**Consultation Response from KC,
Highways Development Management****2026/91638 Amateur Rugby League Clubhouse, Newsome Panthers JARLFC, Hall Bower Lane,
Newsome, Huddersfield, HD4 6RN****Demolition of existing clubhouse and erection of new clubhouse, ancillary works including
additional carparking and improvements to site access****Date Responded: 30 July 2026****Responding Officer: Sheila Henley****Responding Ref: 6-8SE/4****Recommendation: Additional information and revisions.**

Plan ref: A108- Existing Site Plan, Paragon Highways Drawing 0001 Visibility Drawing within the Transport Statement.

Site Plan
1 : 500

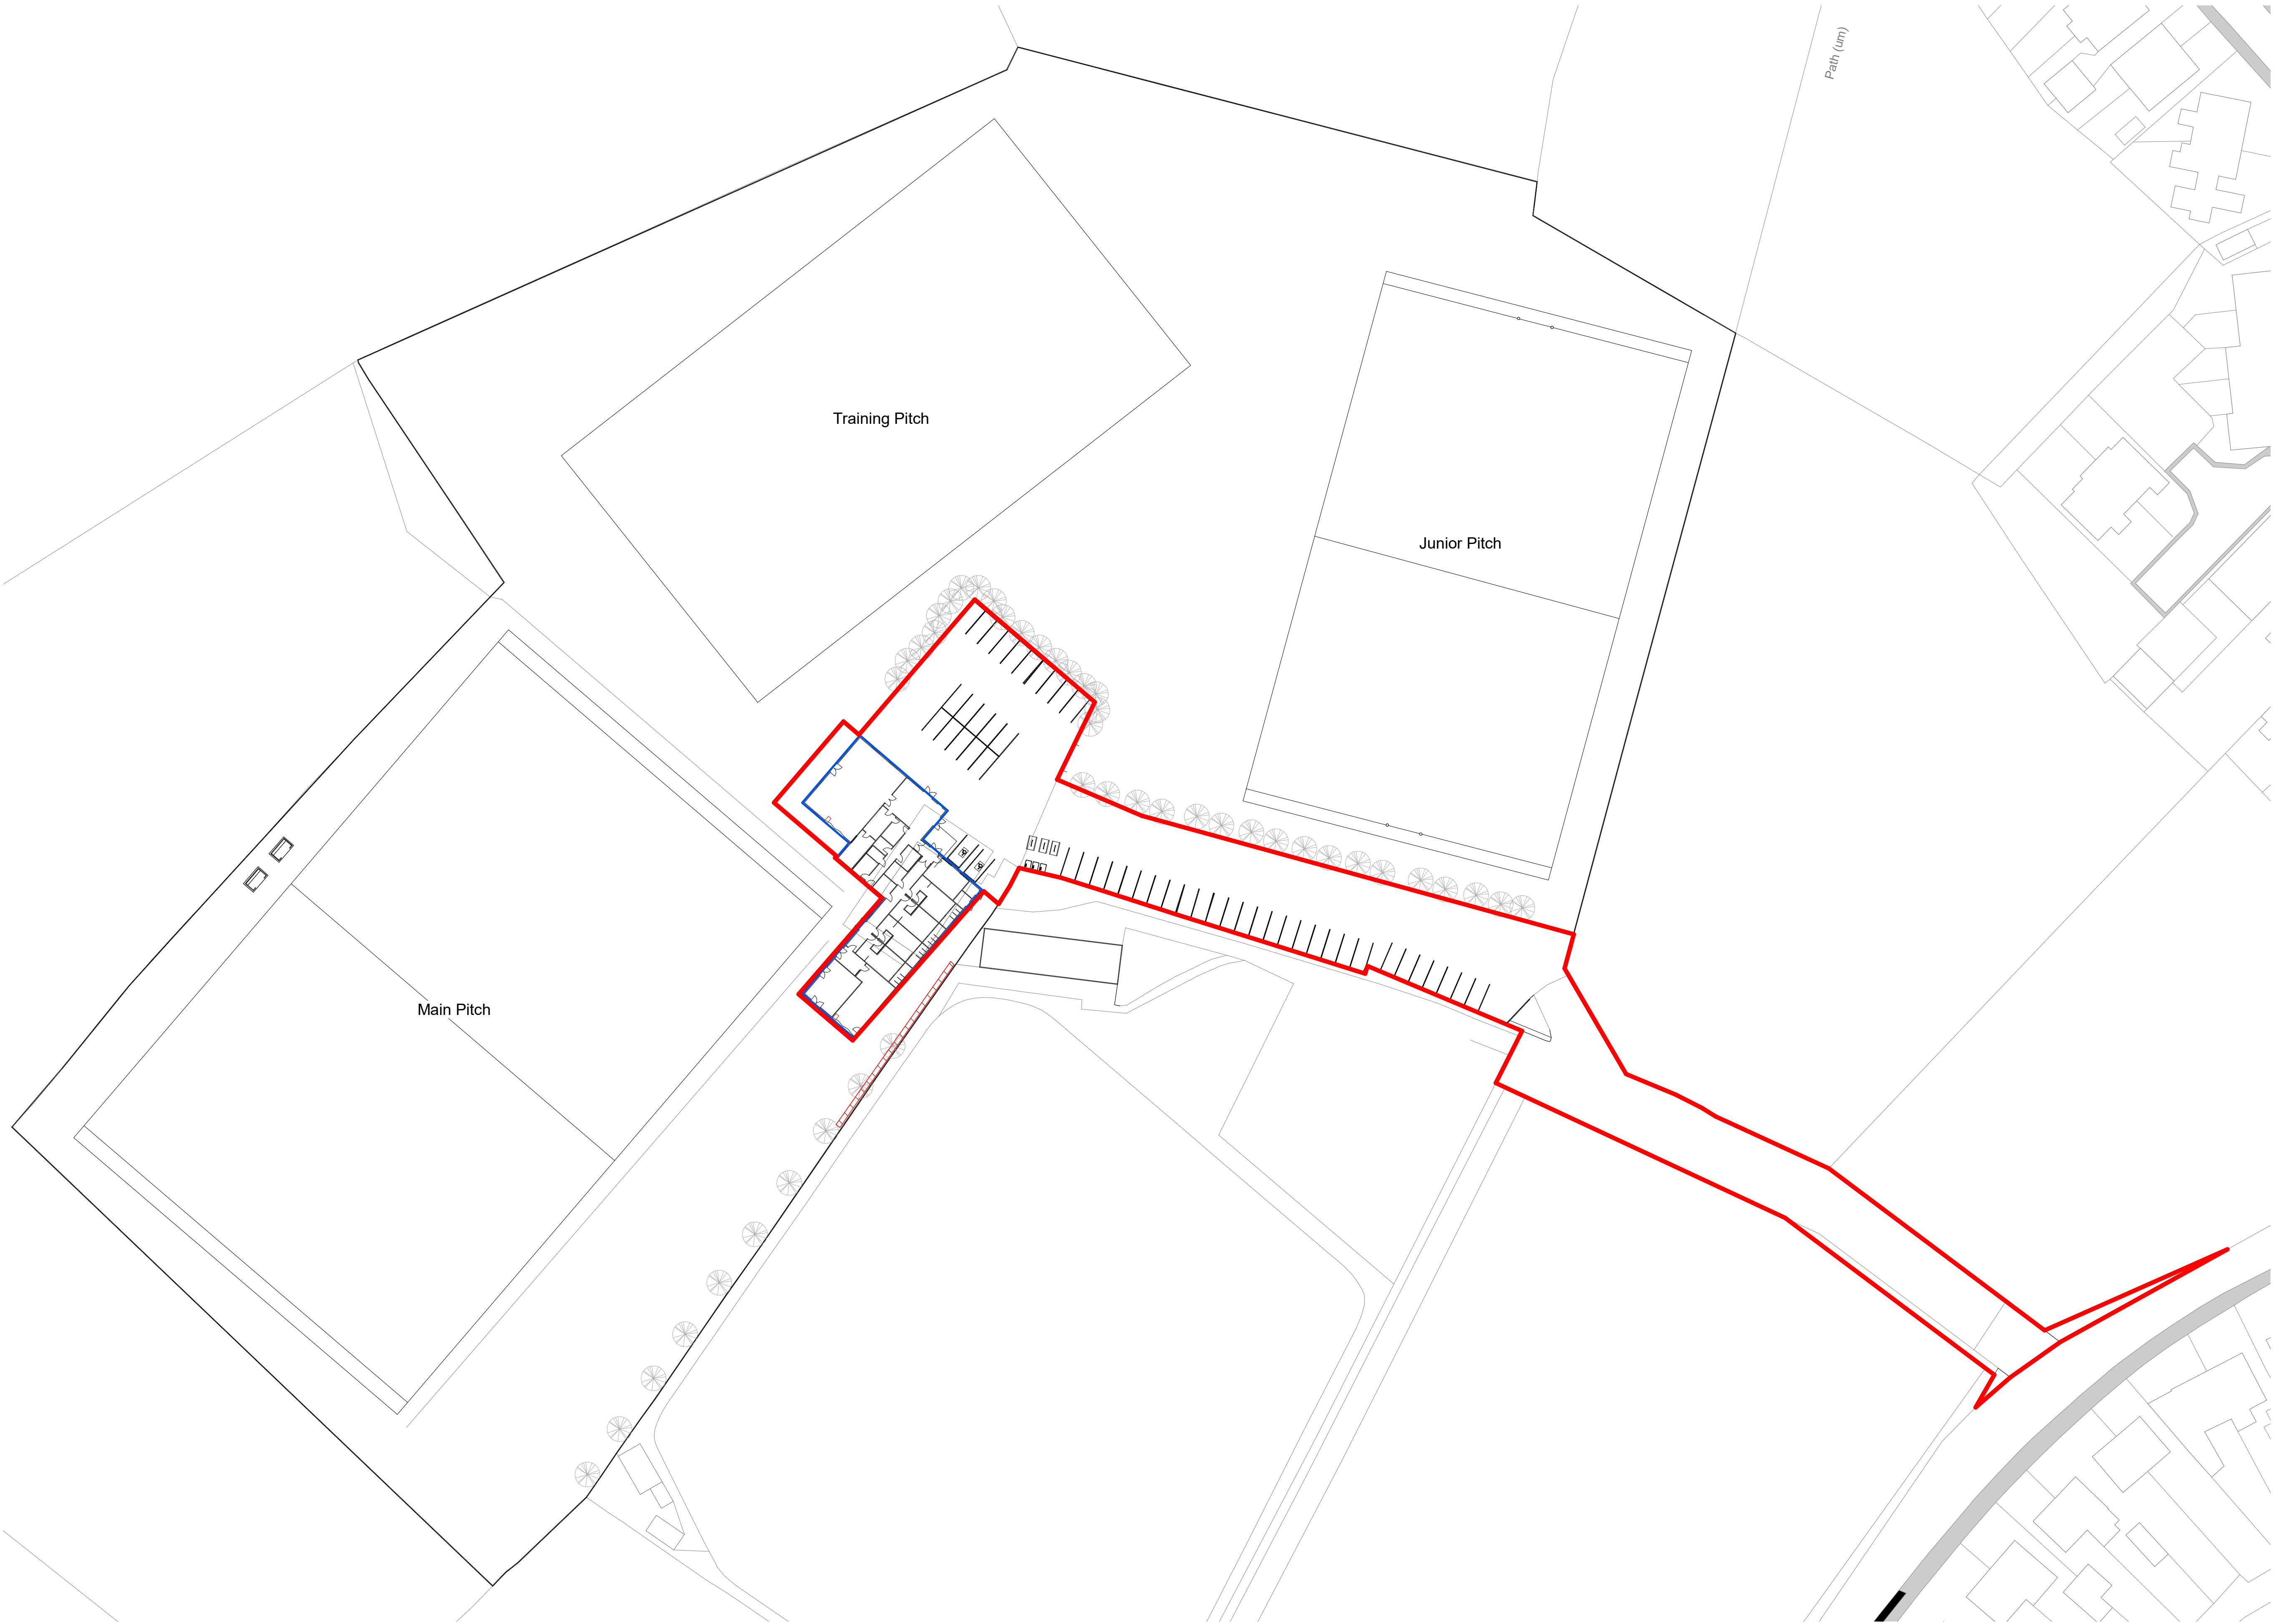
New hardsurfacing should be of a permeable type or a surface water drainage scheme installed. Details are necessary to confirm.

Details of bin storage and confirmation of collection arrangements are necessary.

There is a discrepancy between the submitted documentation and plans over the number of spaces proposed with reference to an increase in 20 spaces from 27 to 47 spaces in the Application Form and a total of 55 in the Transport Statement, and a few more seem to be illustrated on the Block Plan. Clarification is required.

No spaces are shown for accessible bays, passenger vans, or minibuses. Usually, staff bays will need to be allocated and identified by markings or signage. Typically, accessible bays are provided at 5% and evcp's at 10% of the total car parking provision. Motorcycle bays should be considered. Details and revisions are necessary

An amended proposed block plan would be beneficial to illustrate the surface materials and amount of parking and categories of spaces for staff parking and car sharers as well as to show the necessary to provisions for accessible spaces. Verification of bin storage and collection arrangements are required too. Enhancements to sustainable travel, mode choice and the lowering of emissions would arise from cycle parking for staff and visitors but would be increased further by installation of evcp's and other facilities, such as for pedestrians, including the crossing point of the public footpath, and to provide parking for motorcyclists.
